CITY OF ALBUQUERQUE

October 28, 2022

RE: Whataburger Albuquerque
2121 Yale Blvd. SE
Grading and Drainage Plan
Engineer's Stamp Date: N/A
Hydrology File: M15D021A

C-5.0

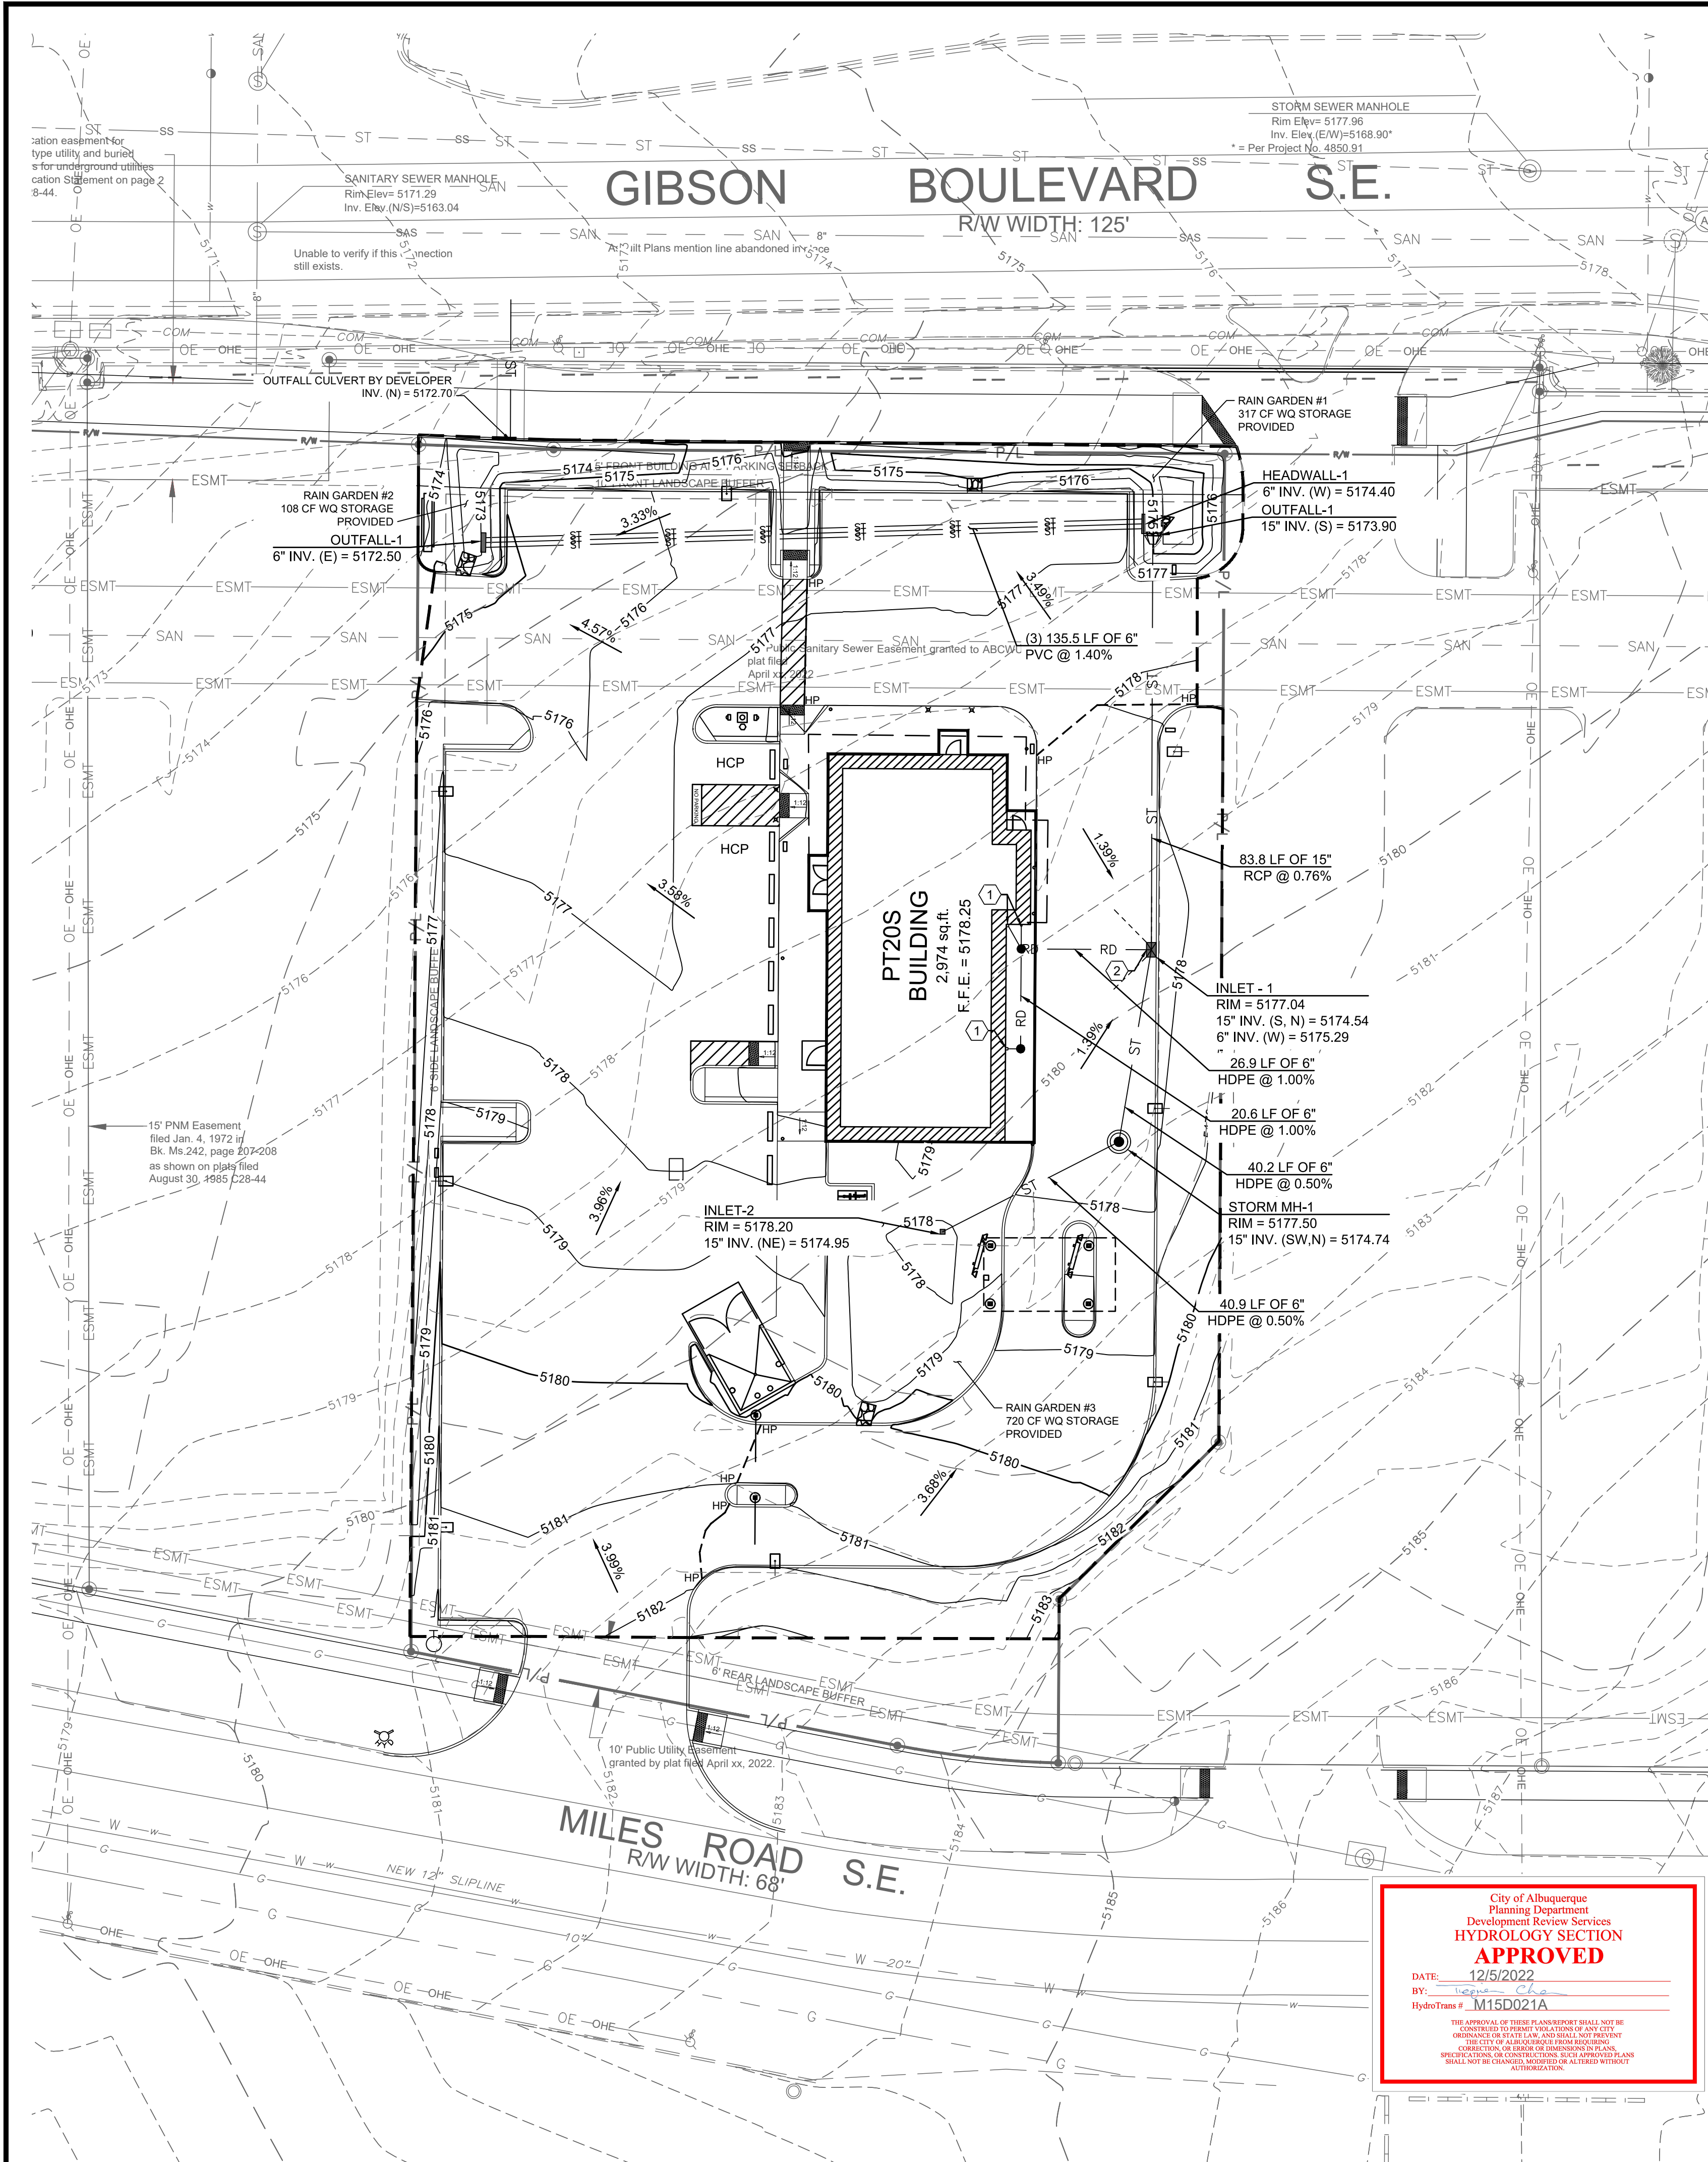
1. Please submit a separate grading & drainage plan with vicinity map, project information, and calculations.
2. Sheet C-5.1: Provide invert elevation to the south.
3. Sheet C-5.1, Storm MH-1: Should the 15" invert SE be SW?
4. Sheet C-5.1: Have the outfall sidewalk culverts completed by the developer? If not, please include the standard SO-19 notes on the plan. An SO-19 permit will be required.
5. Sheet C-5.1: Rain garden #1 encroached to lot E. Please have lot E owner signs an encroachment agreement and record at the County Clerk Office.
